Application for a non-material amendment following a grant of planning permission.

Erection of a three storey building to create 3 x 2-bed self-contained flats, 1 x 1-bed self-contained flat and 1 x studio flat with associated parking, involving demolition of existing chapel.

Reference number:	71295/APP/2017/481
-------------------	--------------------

6. Non-Material Amendment(s) Sought

PROPOSED FLOOR PLANS

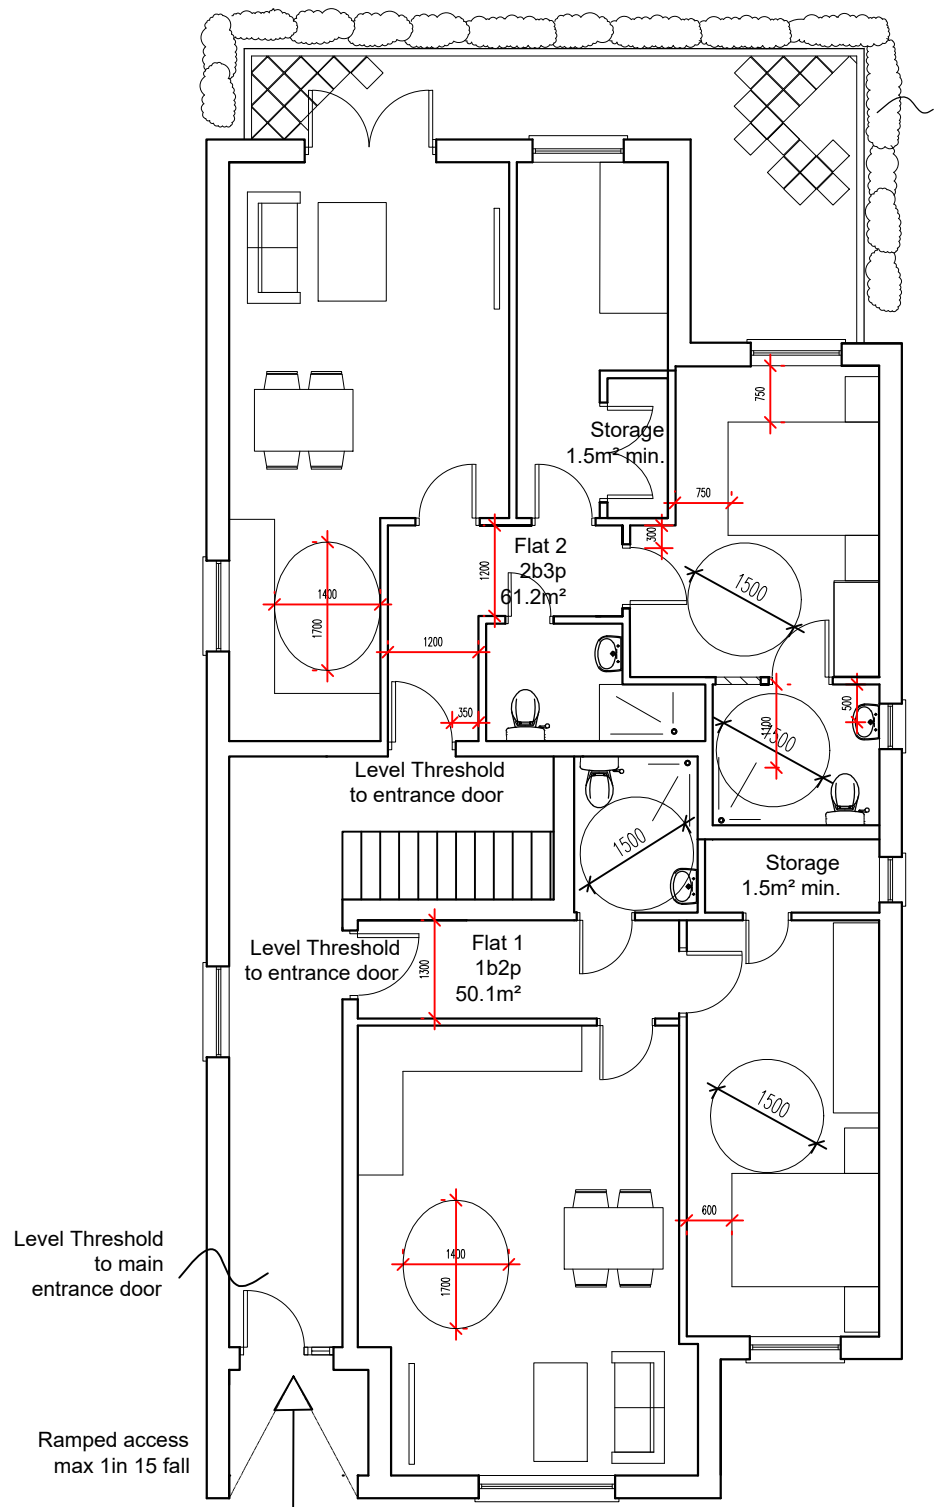
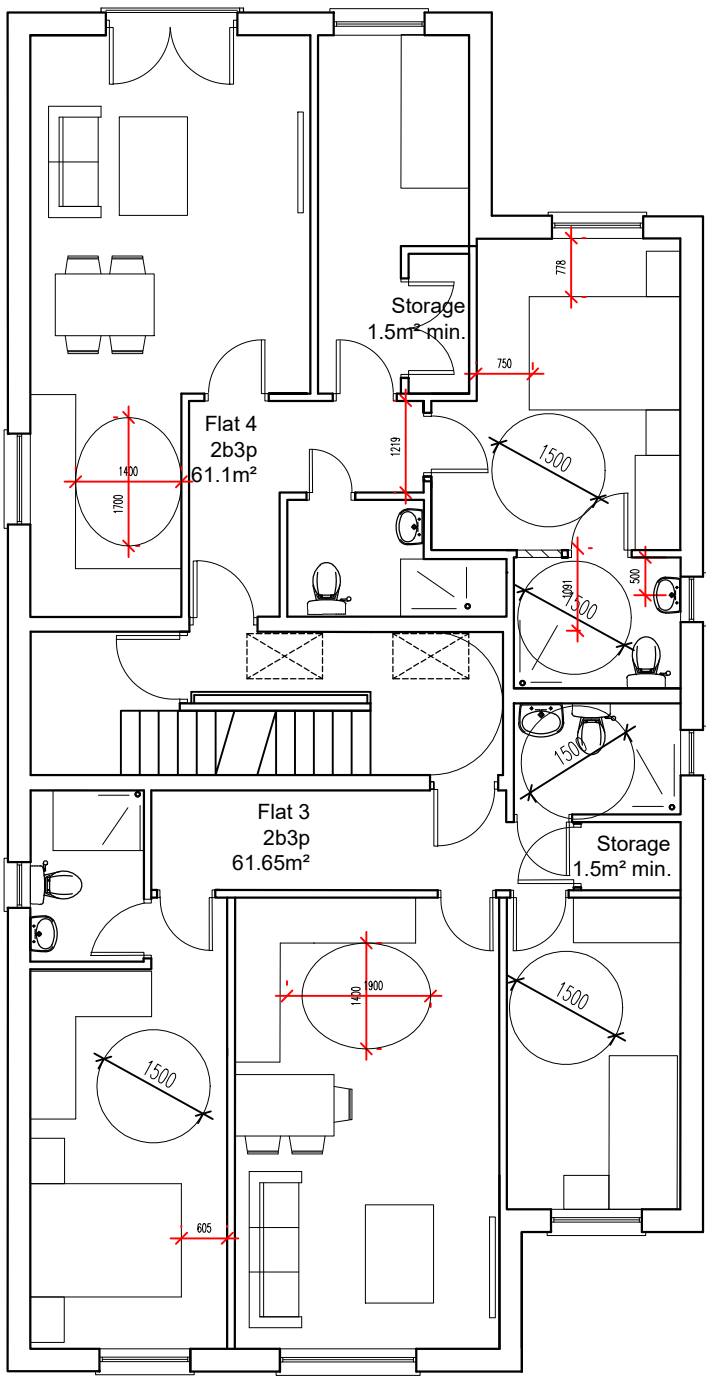
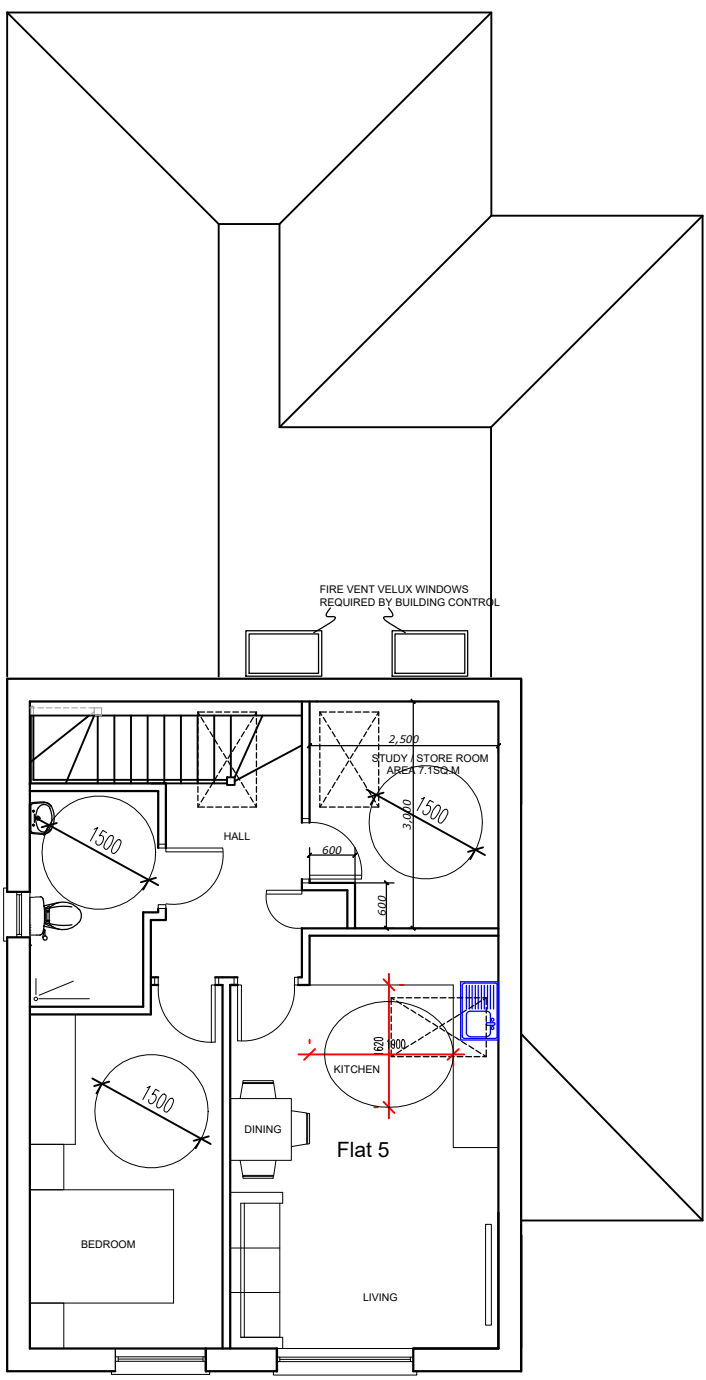
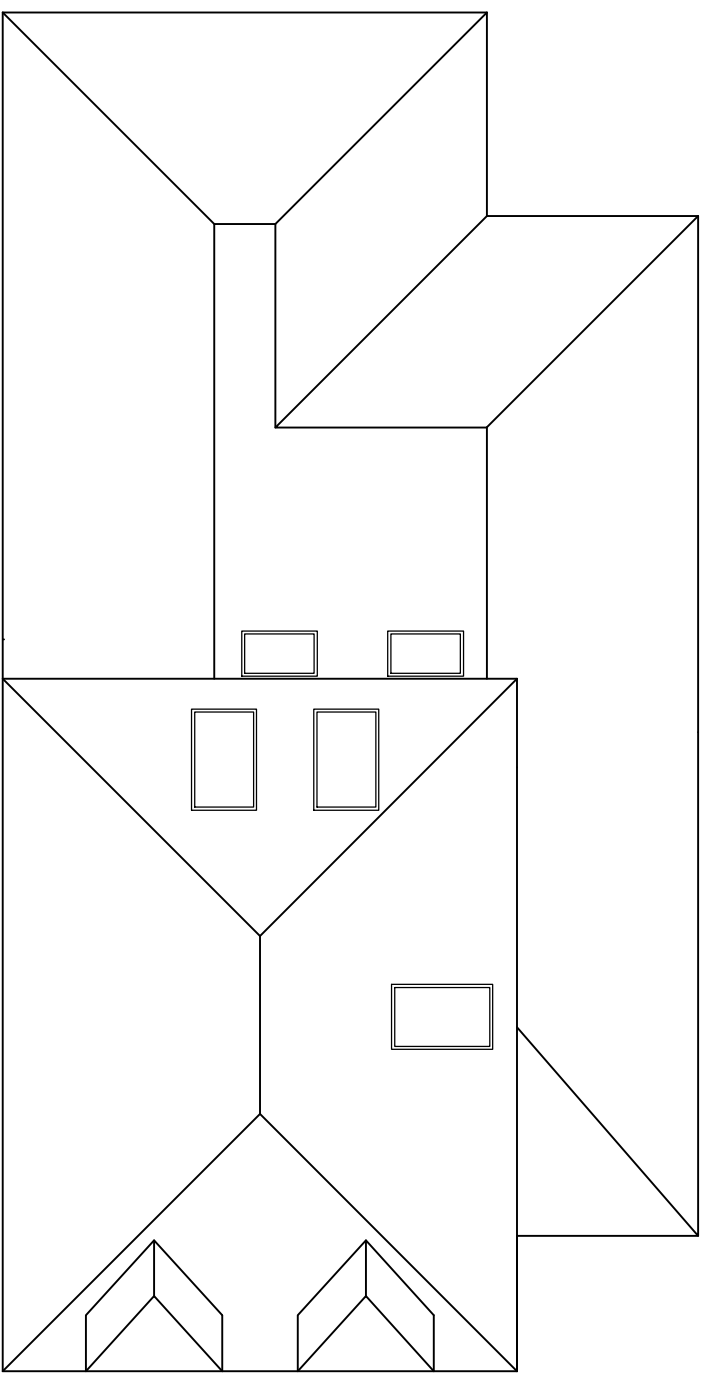
Improve the layout and make better use of the available space of the proposed flats and improve natural lighting by adding more roof lights to the proposed flats and provide smoke ventilation to the common staircase which was required from London Borough of Hillingdon building Control department.
